**ANGEL PLACE  
LEVEL 8, 123 PITT STREET  
SYDNEY NSW 2000**

15 December 2023

## **DESIGN INTEGRITY PANEL ENDORSEMENT - ALEXANDRIA HEALTH CENTRE**

This letter has been prepared on behalf of the Design Integrity Panel (**DIP**) for the Alexandria Health Centre State Significant Development (**SSD**), in relation to the design integrity process. It provides endorsement of the design by the Design Integrity Panel (DIP) prior to the lodgement of the SSDA.

Drawing Title
WEST ELEVATION

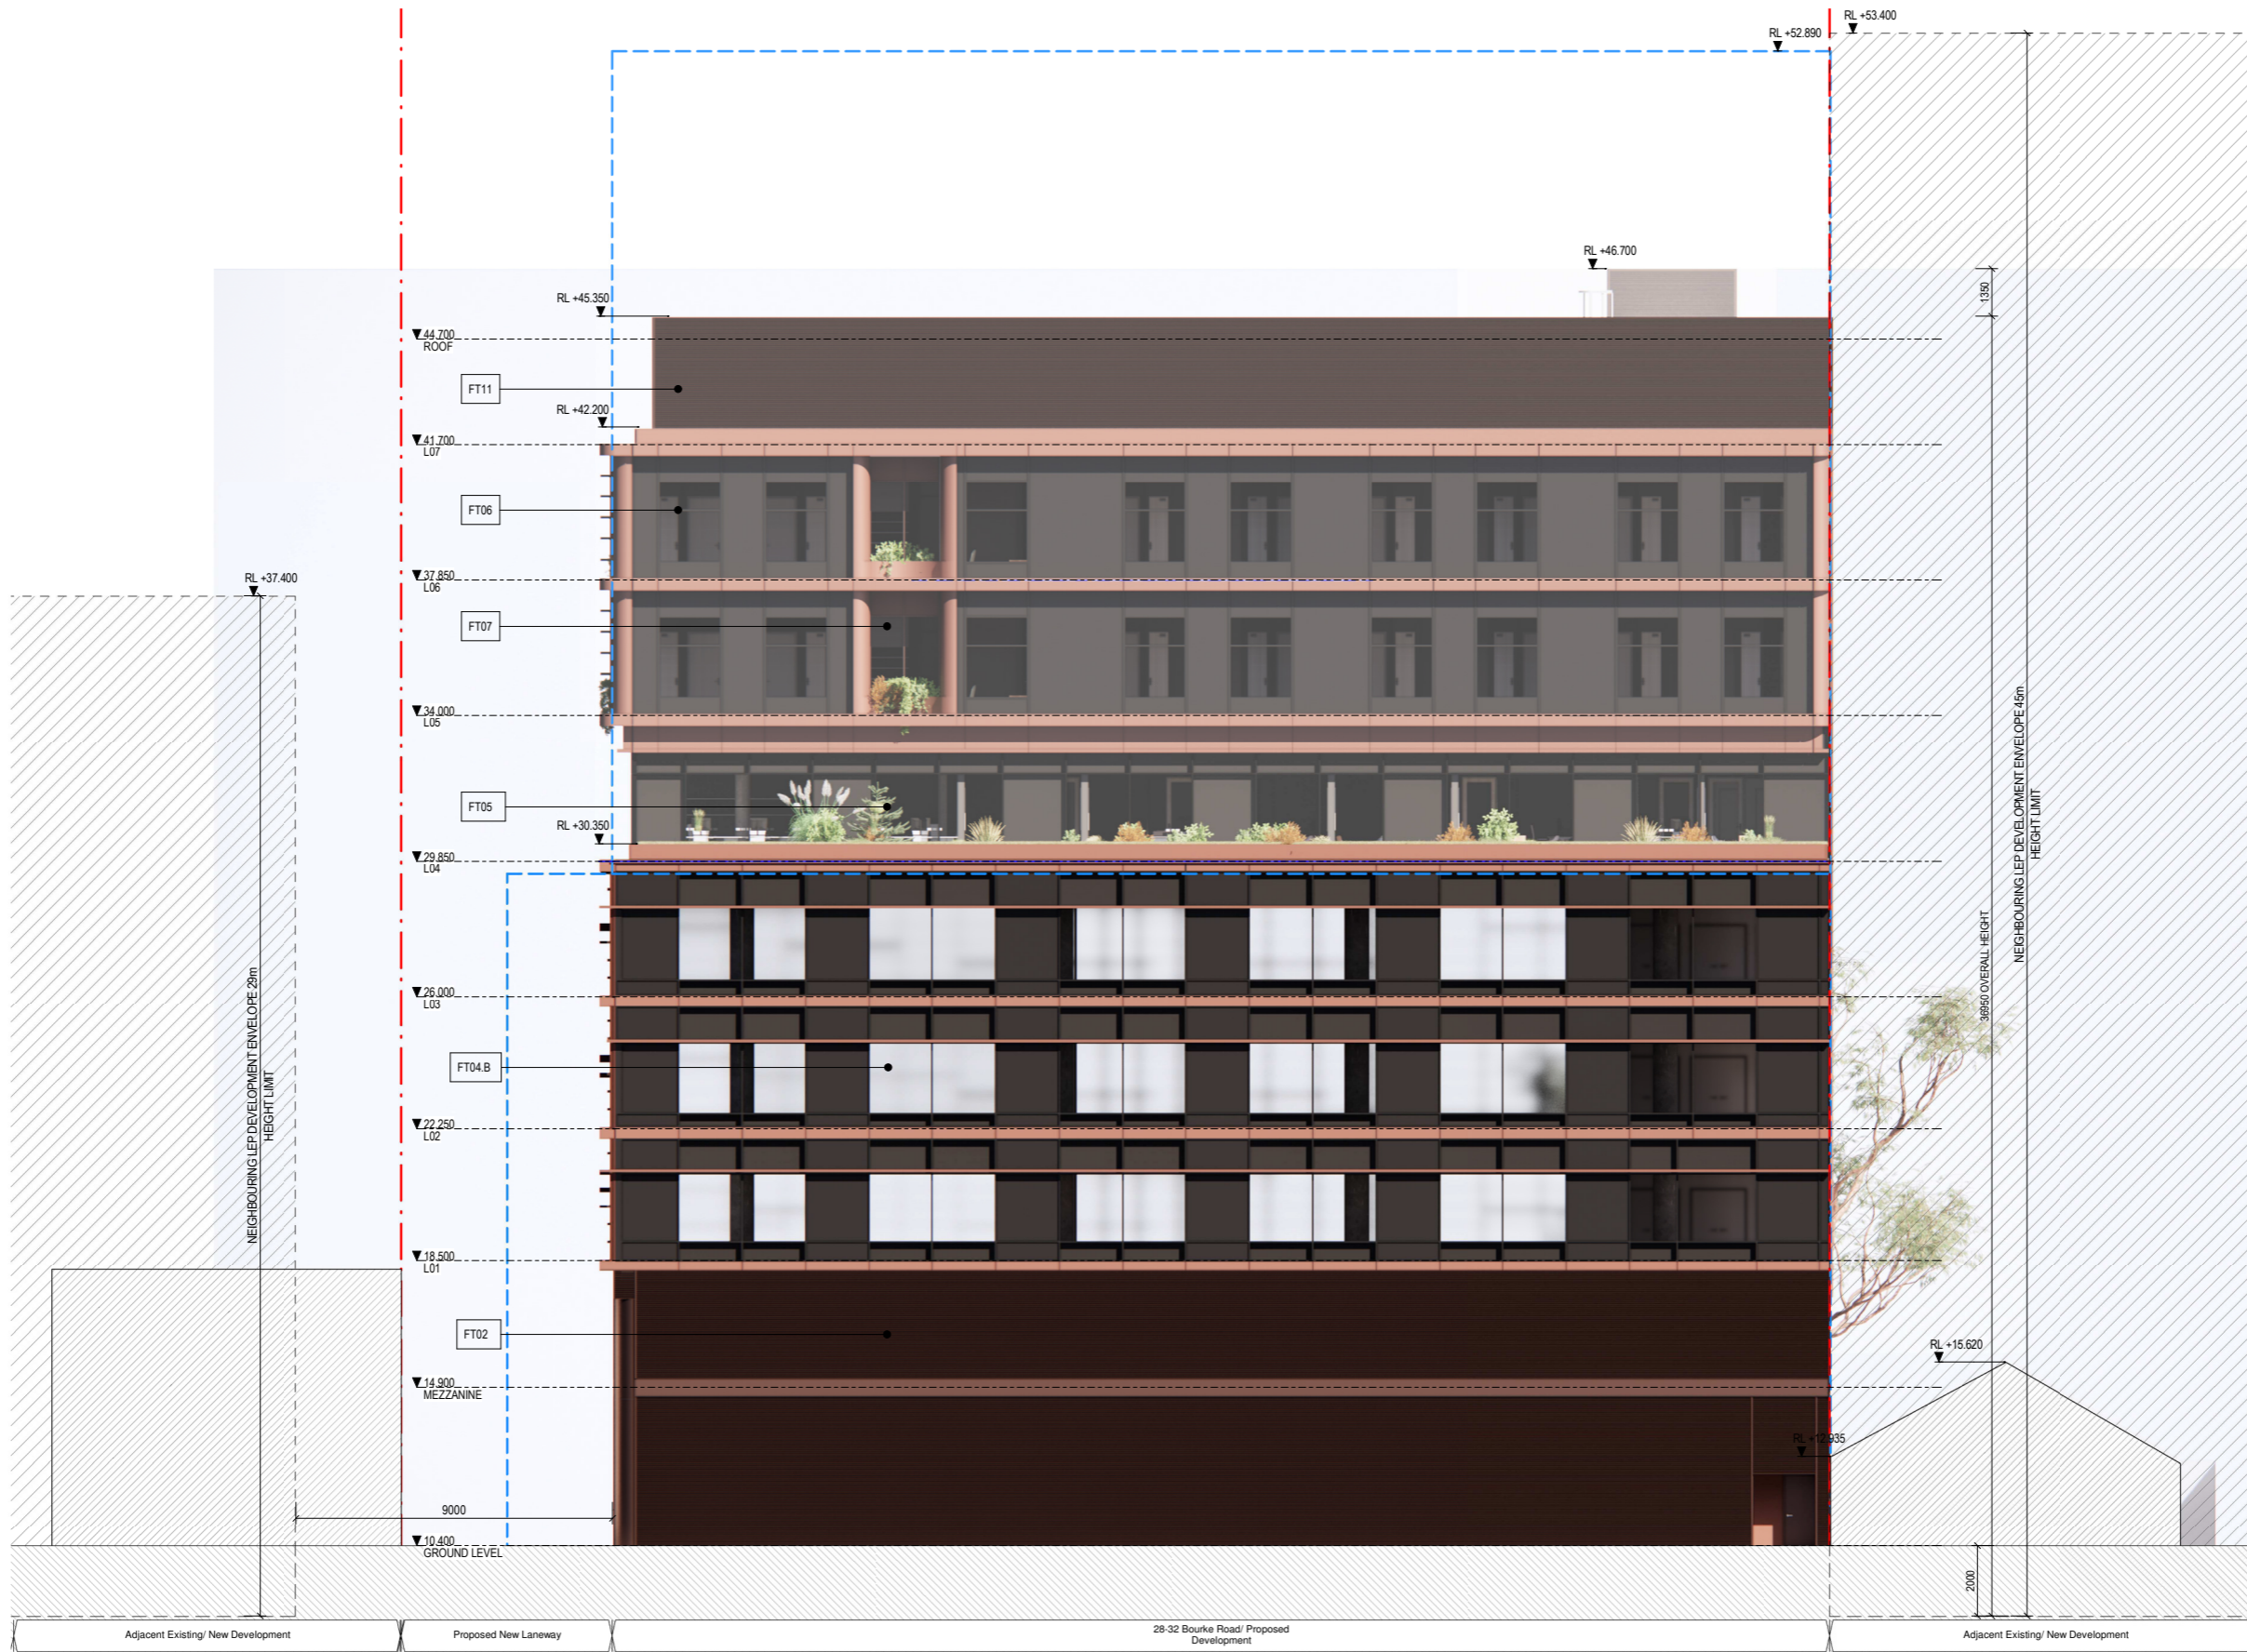
Focus Area	Panel Commentary
	<p>2.3 The use of three 'baguette' façade sizes creates variation and complexity to the façade and is supported by the Panel.</p> <p>2.4 The transition from the Bourke Road façade system to the western façade supported in principle, however the Panel would like to see further details regarding the dimensions during the assessment phase.</p> <p>2.5 The Panel also noted that there maybe complexity in the maintenance of the building which would need to be further considered as the maintenance zone has been reduced.</p>
<p>The Panel unanimously agreed that there was not a need for another DIP meeting ahead of the SSDA lodgement. The Panel noted that there is an opportunity to review the scheme in full and provide comment during the assessment phase of the SSDA.</p> <p>The Panel also noted that this discussion (23 November 2023) was only in relation to the façade design. The Panel will provide detailed comments in the response to submission phase about the scheme as a whole, including (but not limited to):</p>

Focus Area	Panel Commentary
Floor plates and natural light	2.9 Given the size of the floor plates, the Panel suggested there are further opportunities to increase daylight access to occupants of the building. This may be through stepping ceilings towards the edges of the buildings and maximising clear glazing.
Resolution of lateral walls	2.10 The resolution of lateral walls in relation to façade should be carefully managed to retain integrity of façade treatment. The plan pack showed walls in between the mullions on level 4 of the western façade.
